Consultation Response from KC, Highways Development Management
2023/93113 30, Market Street, Huddersfield, HD1 2HG
Change of use and alterations to form student living accommodation with ancillary concierge and communal facilities including roof extension and roof terrace
Date Responded: 09/02/24 Responding Officer: CNB Responding Ref: K5-7NW/57

<b>CLIENT DETAILS</b> MARKET STREET HUDDERSFIELD	<b>DRAWING No</b> NTL-PL-001	<b>REVISION</b>
<b>DRAWING INFO</b> Existing Basement and Ground Floor Plans	<b>SCALE</b> 1:100	<b>DATE</b> 29/09/2023
		<b>DRAWN BY</b> JH

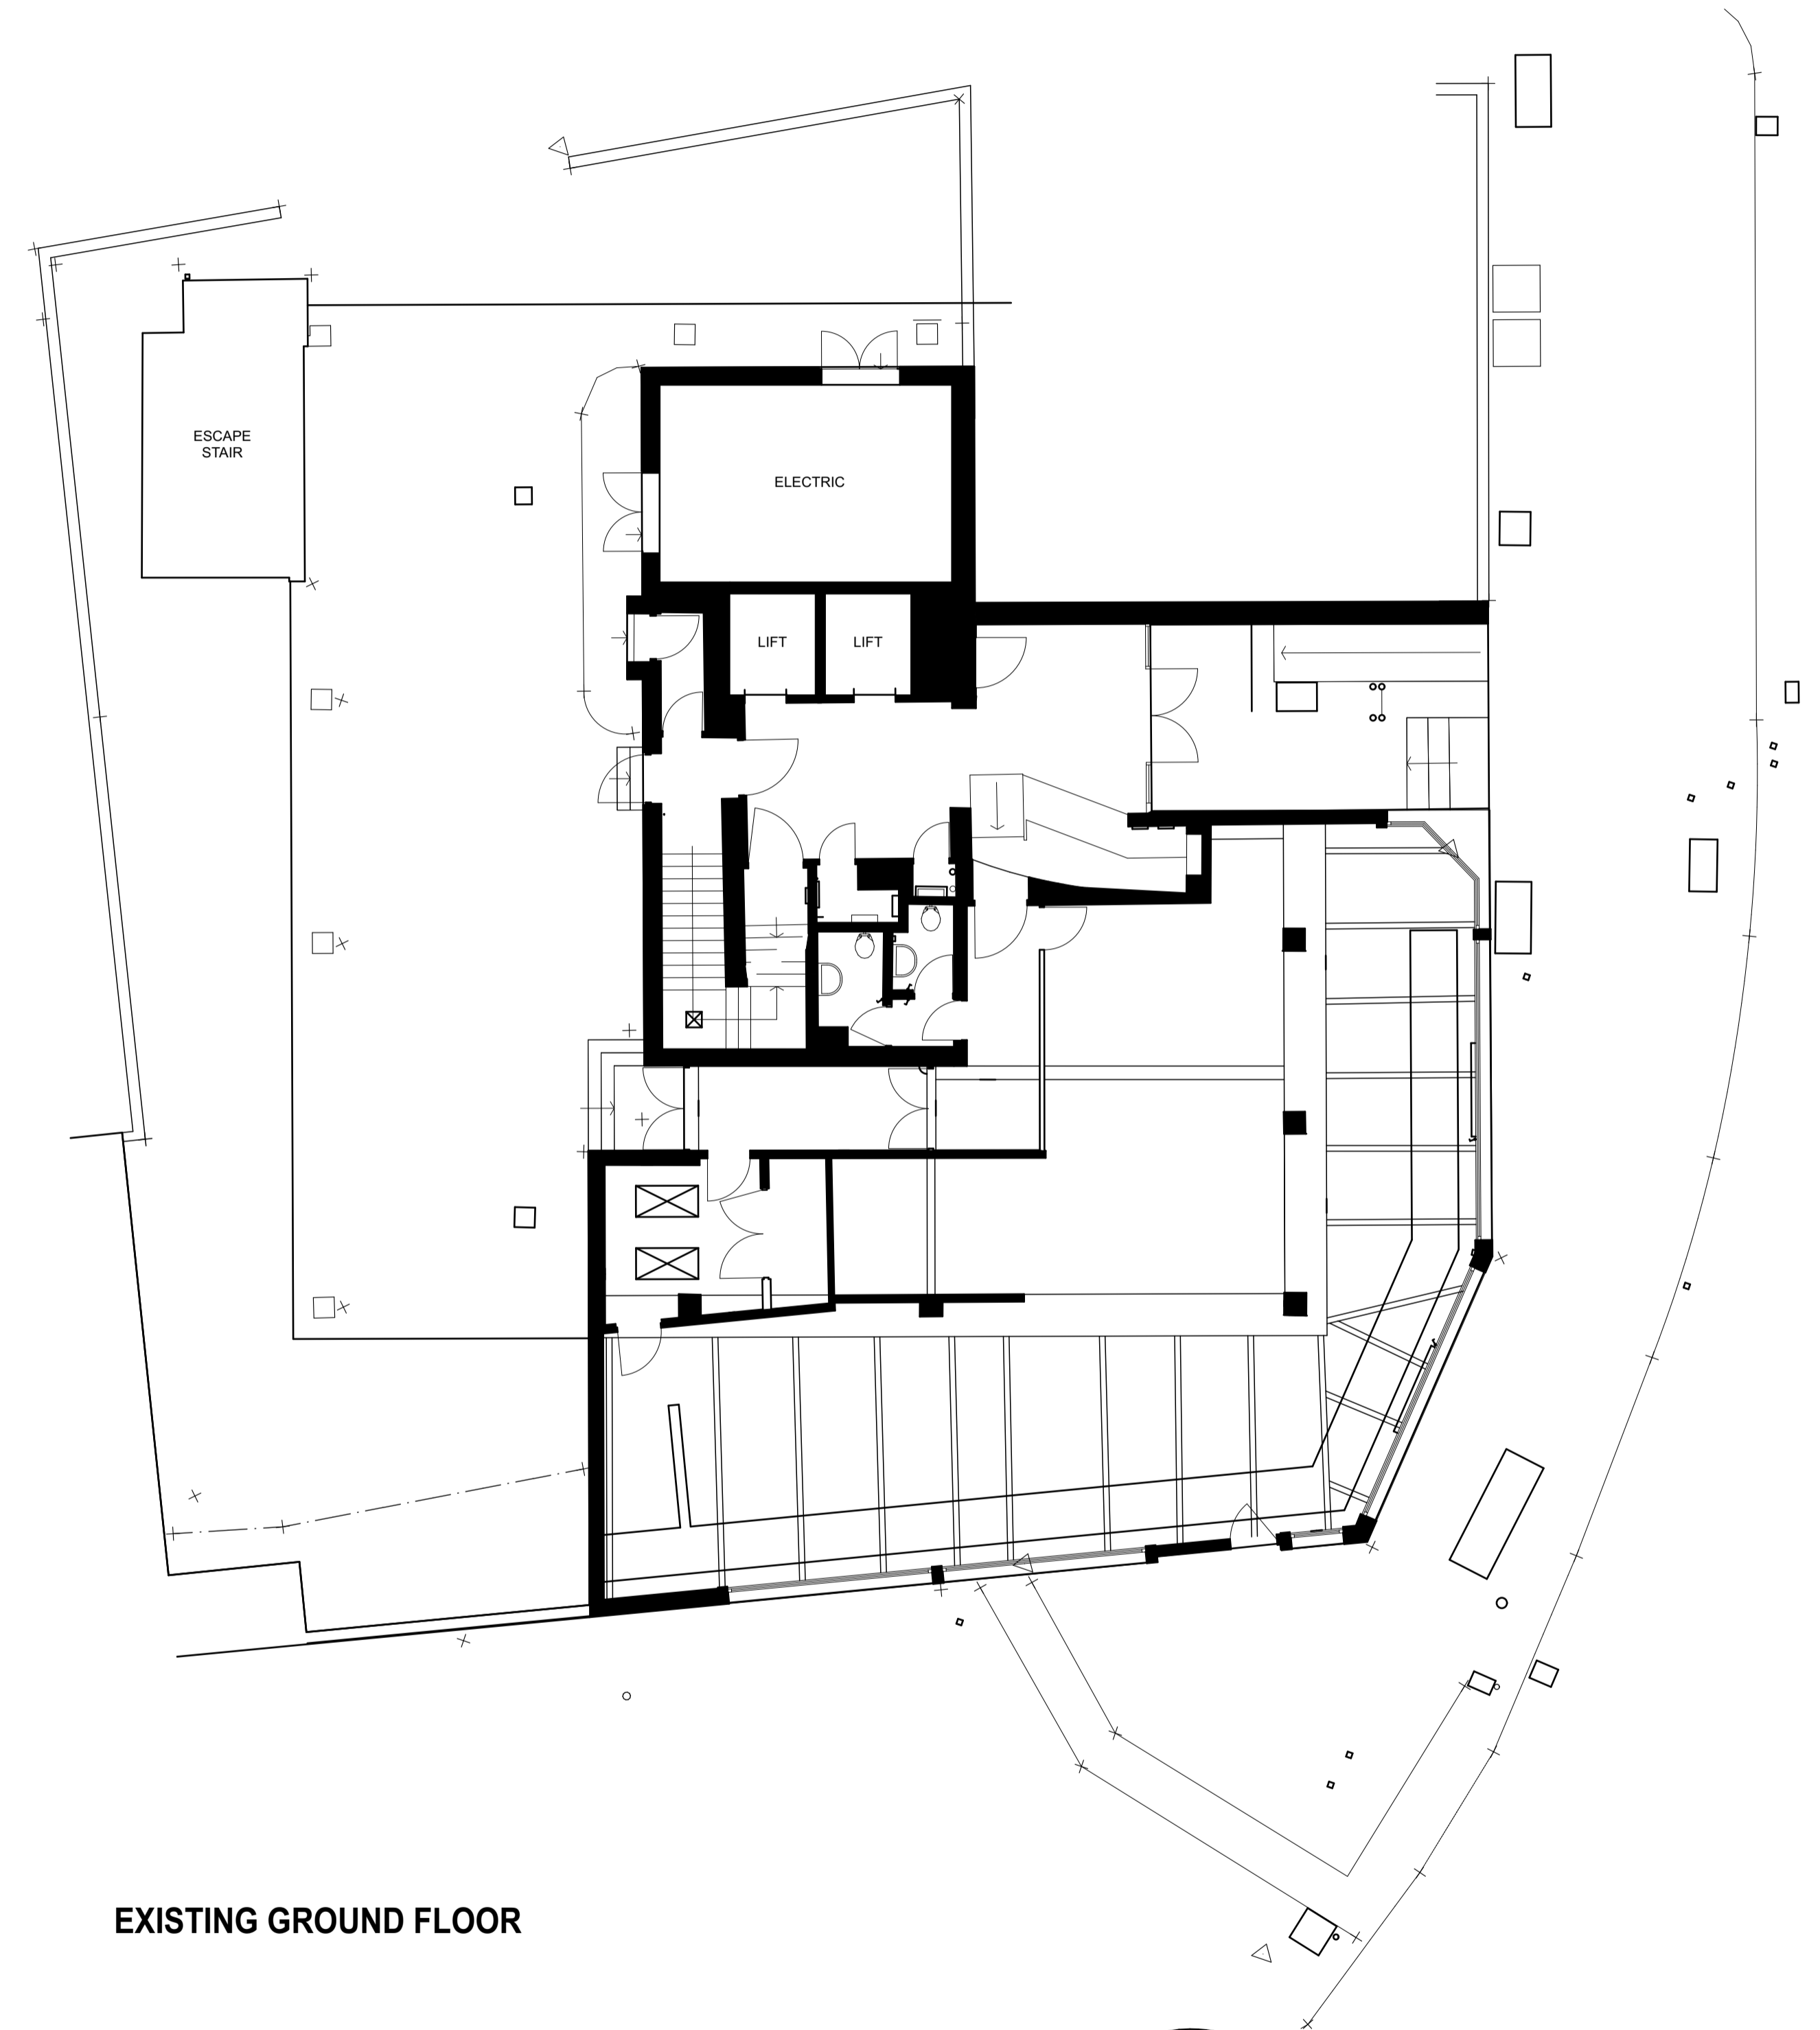
The proposals are for 107 student residential units and the removal of 18 car parking spaces from the basement. This would leave approximately 4 spaces (although street view suggests it may be possible to achieve 5 spaces with a slight shuffle). These are marked as “staff spaces” but it is not indicated if the staff are for the residential units or for the commercial unit, this information should be provided as part of a parking management plan.

Due to the sustainable town centre location and the type of accommodation being applied for, we would not insist on vehicle parking for the residents, however there will be a demand for parking for drop-off and pick-up at the start and end of each term and some parking should be provided for this. As there is only a limited number of parking spaces then they will need to be carefully managed with space bookings required for students being dropped-off/picked-up. This should be provided as a parking management document that explains in detail how the booking process will operate and be managed by staff on site to avoid over occupation of spaces. This should be conditioned.

The development shall not be brought into use until a Servicing and Car Park Management Plan has been submitted to and approved in writing by the Local Planning Authority. The Servicing and Car Park Management Plan shall include details of:

- i. Liaison member of staff and contact details
- ii. Restrictions on apartment occupants parking on site and details of any contracts stating this.
- iii. Staff parking arrangements (including types of staff entitled to a space)
- iv. Booking system for parking spaces for start/end of term drop-off/pick-up.
- v. Mechanism for review of the Car Park Management Plan
- vi. waste bin management to place bins in a suitable collection location (not causing obstruction of the adopted highway or footway) and replace them to the appointed storage area after collection.
- vii. Mechanisms in place to avoid waste collection and servicing occurring during days proposed for drop-off and pick-up at the start and end of term.
